LU/338/14/PL
Cover letter

Re: 44 East Ham Road Littlehampton – LU/338/14/PL

Further to your letter of the 5 November and our telephone conversation to-day, I enclose three copies of amended drawing no.01 with the date 13/11/2014 on which I have altered the proposed block/site plan at 1:200 to include the adjoining properties at 42 East Ham Road and 1 North Ham Road.

PROPOSED SOUTH VIEW

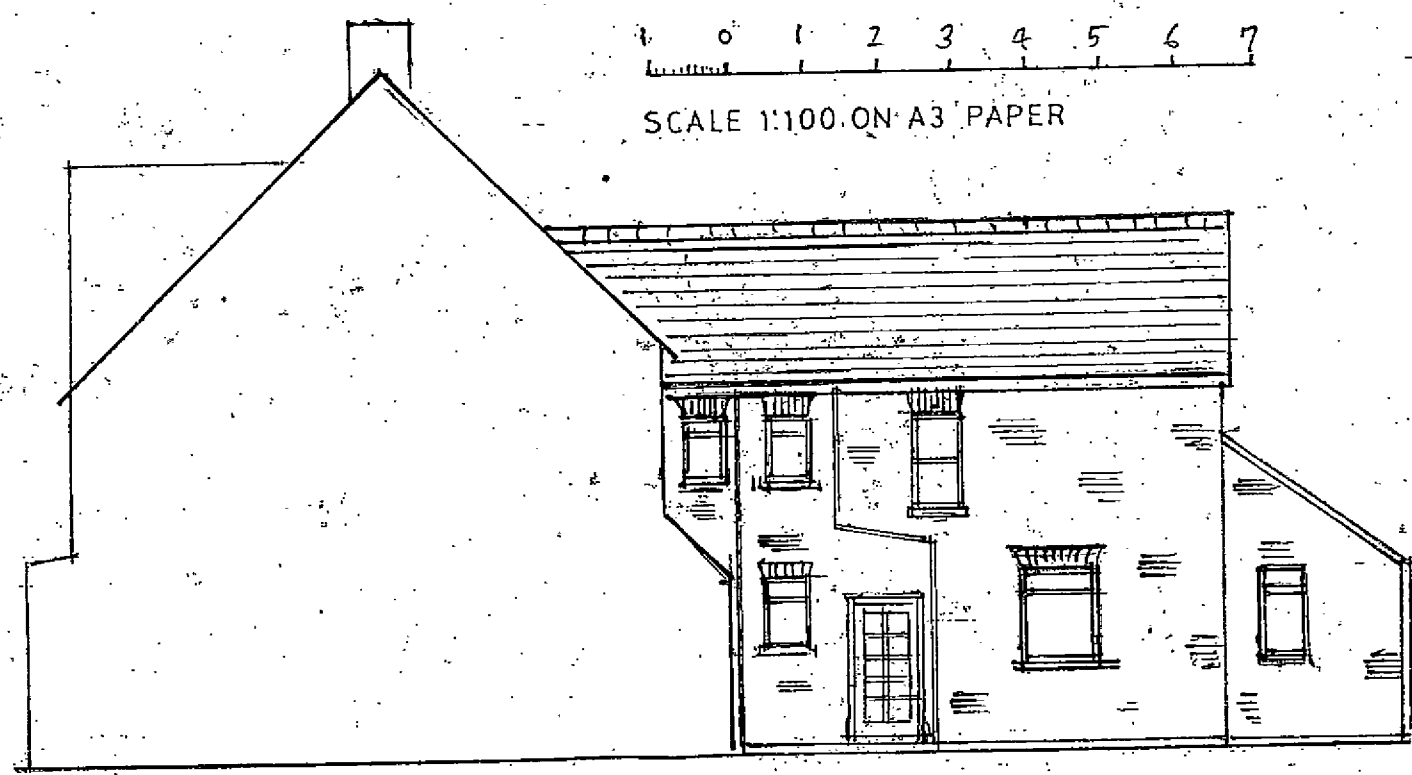
As agreed, the south (not north as per your letter) elevation drawings remain unchanged as the roof window is only to the roof space, not the first floor room below.

PROPOSED BLOCK/SITE PLAN
SCALE 1:200 ON A3

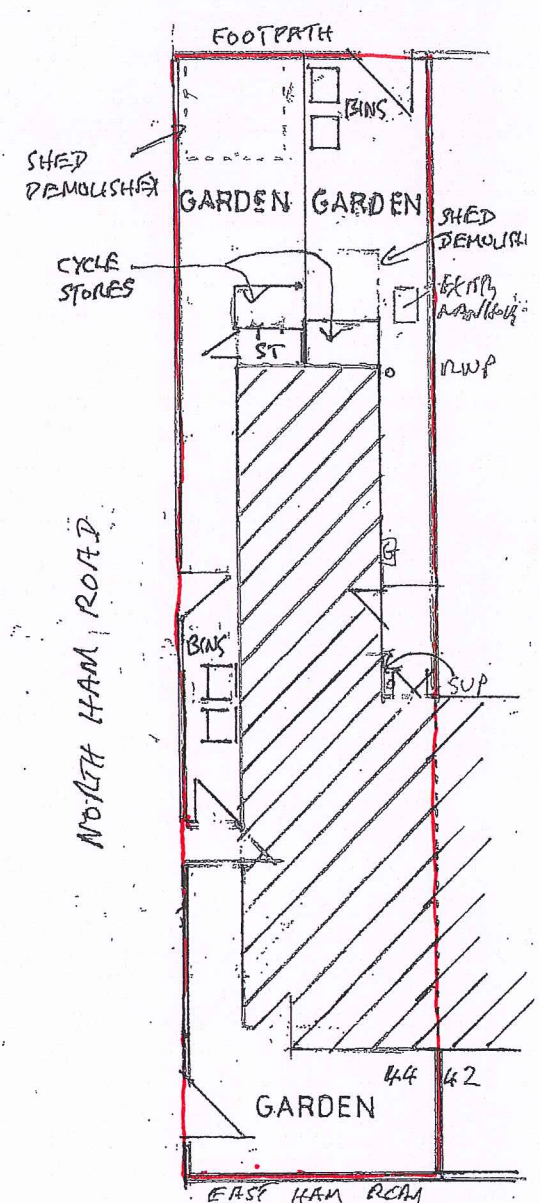
The plan also shows the position for the two proposed cycle stores which will each take two cycles. Also, enclosed are the copies of details of the proposed cycle stores.
